**TII submission to Proposed windfarm development at Lemanaghan and surrounding townlands
- An Coimisiún Pleanála - Case reference: ACP ref. PAX19.324161_TII ref. TII23-135837**

TII26-135837

PAX19.324161

RE: Proposed development of 15 no. wind turbines, a permanent 220kV on-site substation, and associated infrastructure located at Lemanaghan and surrounding townlands, Co. Offaly.

PROJECT TITLE: Lemanaghan Wind Farm, Co. Offaly			
DRAWING TITLE: Underpass Arrangement - Plan & Section			
PROJECT No.: 200804	DRAWING No.: 200804-39	SCALE: As Shown @ A2	
DRAWN BY: FB	CHECKED BY: GO	DATE: 23.03.2026	REVISION: P01

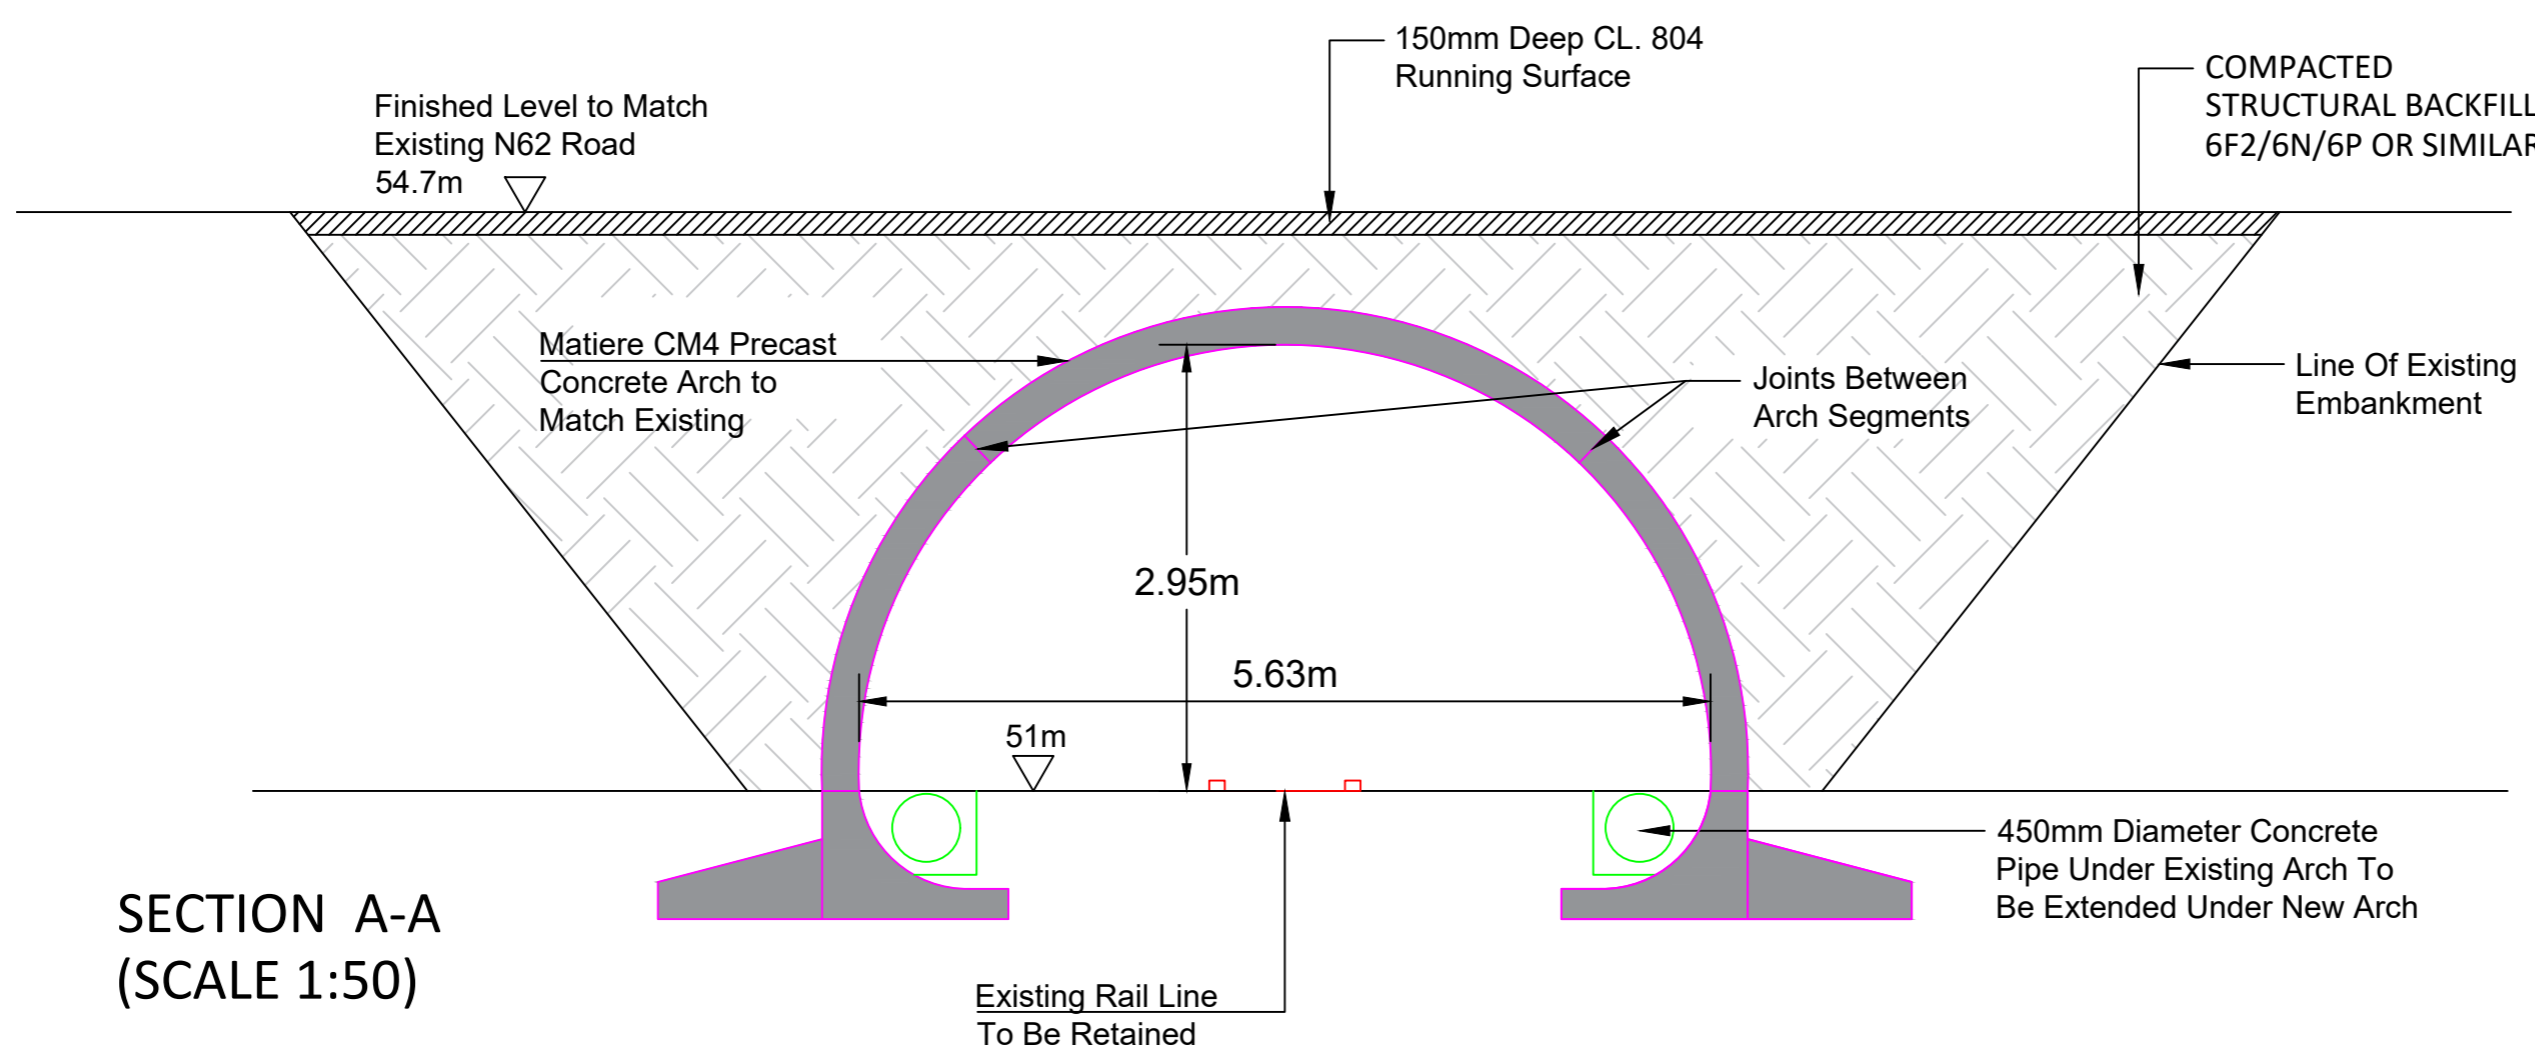
TII notes that submitted EIAR "Chapter 4 Description of the Proposed Project", includes an element of development under section 4.7.3 *Turbine Component Transport Route* described as an "underpass extension" further described in EIAR subsection 4.11.1.4 *Underpass Extension at Site Entrance 1* and depicted on submitted Drawing titled: *Underpass Arrangement - Plan & Section* (Dwg. No. 200804-39, Rev. P01, dated 23.03.2026).

TII observes this the proposed "underpass extension" is immediately adjacent an N62 overbridge (Eirspan name: *Industrial Railway Bridge*, Eirspan ID: *OY-N62-008.00*) which is a TII Structure. TII is unable to ascertain whether the proposed "underpass extension" will necessitate the undertaking by the developer of the procedure under TII Publication *DN-STR-03001 - Technical Acceptance of Road Structures on Motorways and Other National Roads*. This Standard specifies the procedures to be followed, in order to obtain Technical Acceptance for structures on motorway and other national road schemes and for the submission of as built records. The procedures cover the design of all road structures, including bridges, tunnels, subways, culverts, buried corrugated steel structures, retaining walls, reinforced earth structures, gantries, environmental noise barriers and temporary structures under or over motorways or other roads carrying public traffic. The Technical Acceptance Requirements for the assessment, alteration, modification, strengthening and repair of all road structures must be prepared in accordance with the TII Standard: TII Publication *DN-STR-03001 - Technical Acceptance of Road Structures on Motorways and Other National Roads*.

Acceptance of Road Structures on Motorways and Other National Roads has been undertaken. It is reiterated that from the information submitted, TII is unable to determine potential impact on the TII Structure and therefore necessity of the undertaking of necessary technical acceptance procedures under the relevant TII Publication DN-STR-03001.

Having regard to the potential for the proposed underpass extension to interact with the TII Structure (Eirspan name: *Industrial Railway Bridge*, Eirspan ID: *OY-N62-008.00*), detailed design and execution of the proposed “*underpass extension*” will be required to demonstrate compliance with TII Publication DN-STR-03001 - *Technical Acceptance of Road Structures on Motorways and Other National Roads*, as appropriate.

- iv. Any works to structures forming part of the national road network requires TII Technical Acceptance in accordance with TII Publication DN-STR-03001 - *Technical Acceptance of Road Structures on Motorways and Other National Roads*. Detailed design information in respect of the proposed underpass extension immediately

adjacent an N62 overbridge (Eirspan name: Industrial Railway Bridge, Eirspan ID: OY-N62-008.00) up to and including undertaking off technical acceptance procedures as appropriate shall be required to be agreed with the Road Authority prior to the commencement of any development on site.

PROJECT TITLE: Lemanaghan Wind Farm, Co. Offaly			
DRAWING TITLE: Proposed Amenity Car Park post construction works			
PROJECT No.: 200804	DRAWING No.: 200804 - 44	SCALE: As Shown @ A3	
DRAWN BY: GO	CHECKED BY: RD	DATE: 23.03.2026	REVISION:. P01

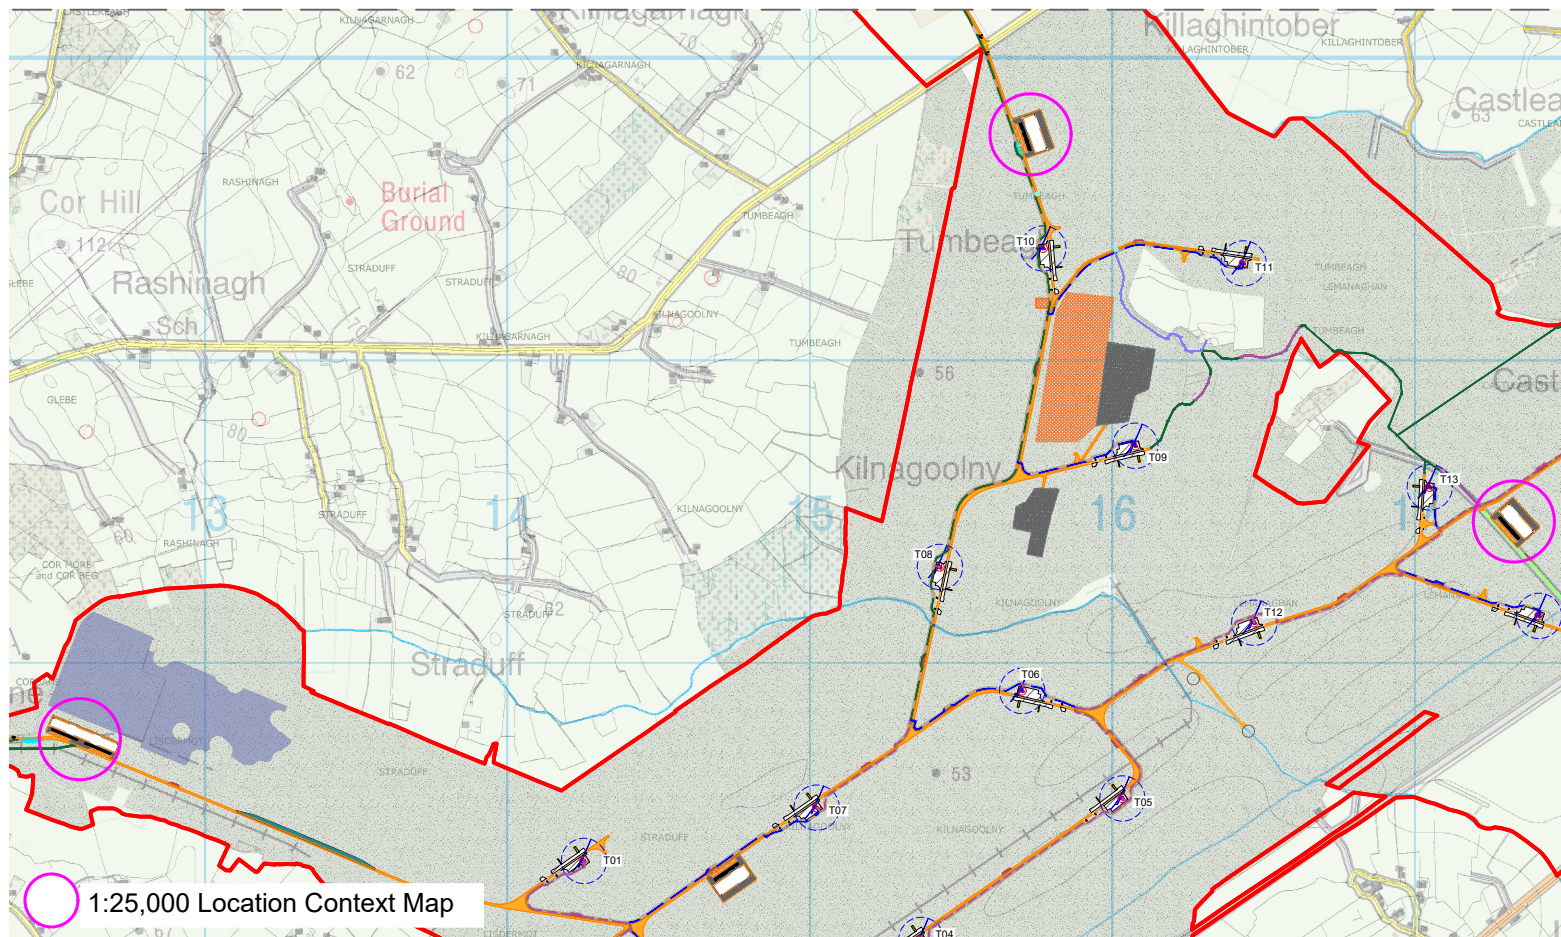
TII is seriously concerned that one “*amenity car park*” is indicated to be accessed directly from the N62 at a location where the maximum 100kph speed limit applies which is in contravention of official national roads policy and contrary to road user safety and the safety of the public generally.

In consideration of the foregoing, TII reiterates its concern that one "*amenity car park*" remains indicated to be accessed directly from the N62, as opposed to a temporary, monitored and limited private construction entrance, at a location where the maximum 100kph speed limit applies. This also conflicts with The Authority's concern arising having regard to the nature of the proposed associated amenity entrance which will attract public multimodal usage which is contrary to the provisions of official national roads policy, and more critically to safety of visitors and users generally.

In order to address the deviation from relevant *Spatial Planning and National Roads Guidelines for Planning Authorities* and Offaly County Development Plan policy and road safety that the proposed amenity access represents, the Authority strongly recommends the omission of the proposed amenity usage of the N62 entrance in any final grant of decision.

1. Prior to the commencement of development, revised details including operational phase site layout plans clearly demonstrating no access for the public to proposed amenity car parks from the N62 shall be submitted for the written agreement of the planning authority subject to the written agreement of TII. The access off the N62 shall not be utilised for public amenity access to the development site.

Figure 15.6a Site Entrance 1 – N62 / Wind Farm access junction, junction layout

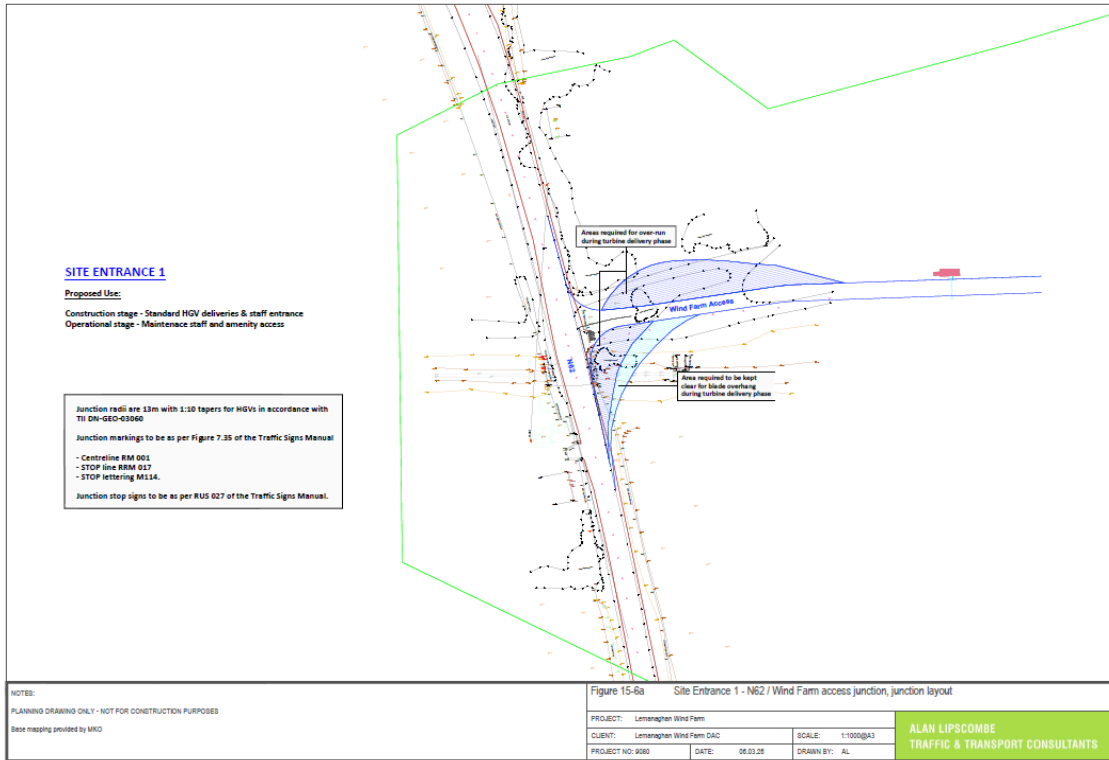
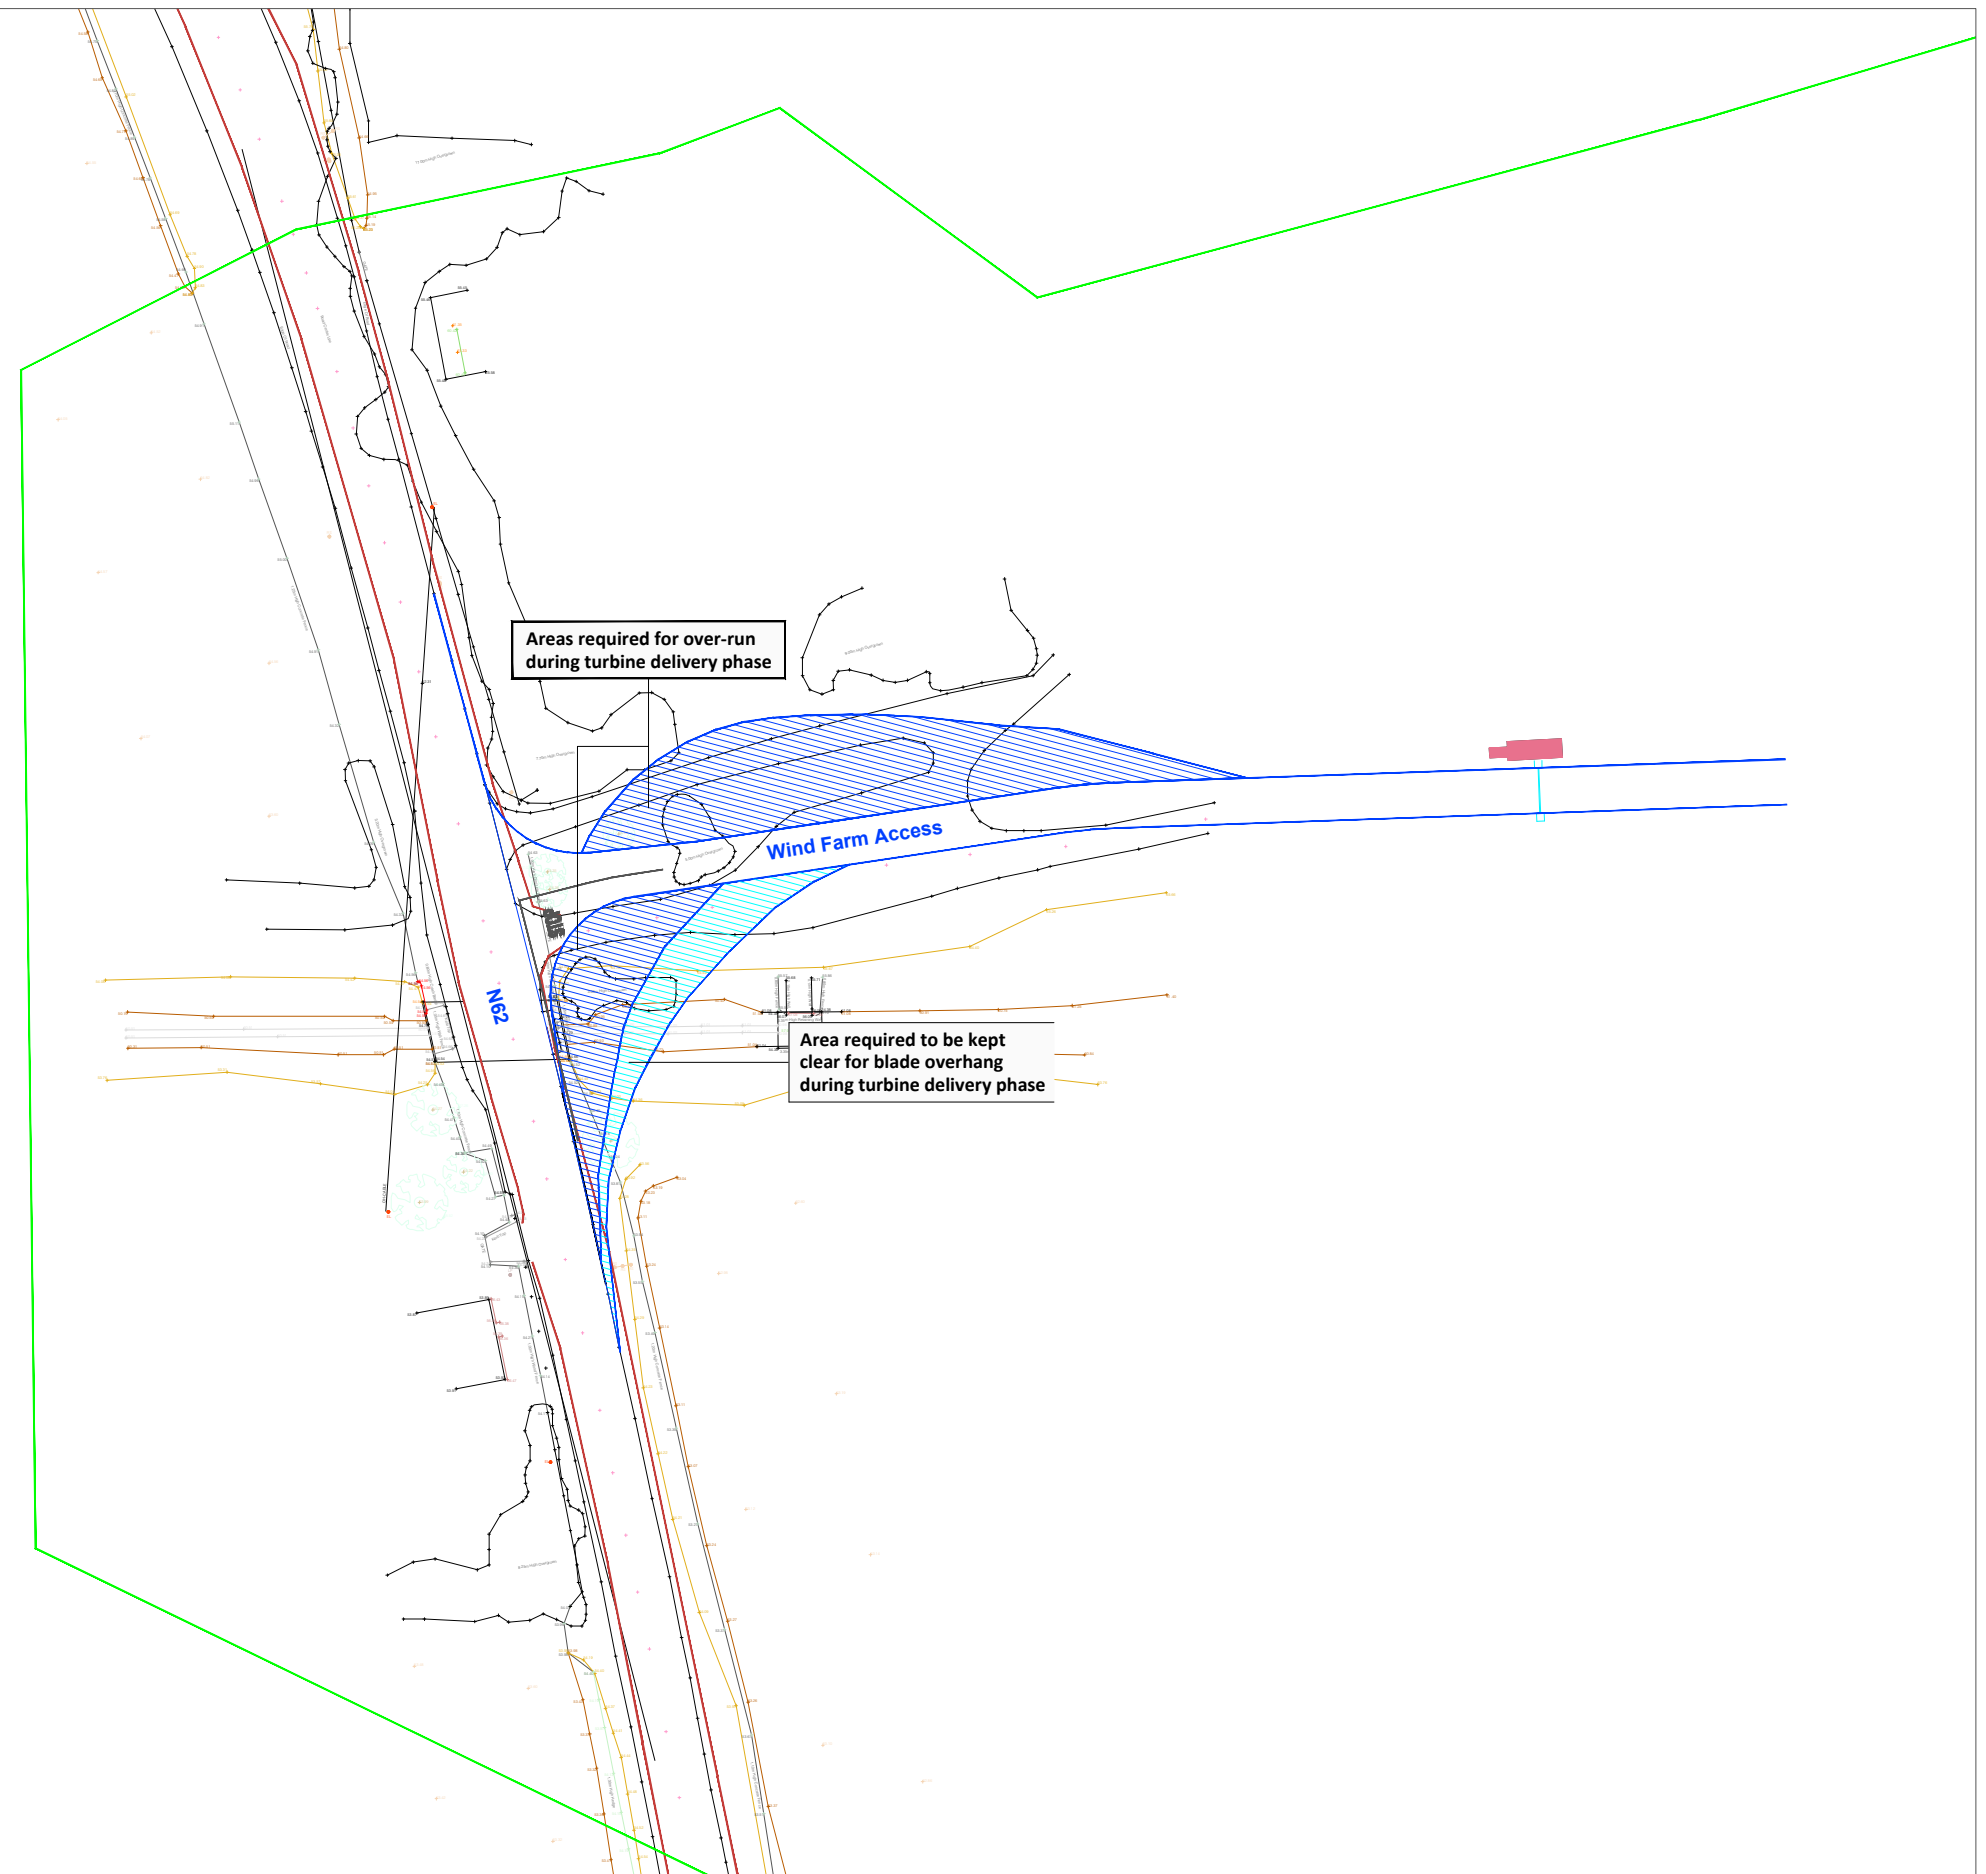
to utilise the N6, M6, N52 and N62 all part of the national roads network. In addition, the N62 access is identified as “*Site Entrance 1*” for the purposes of the construction phase.
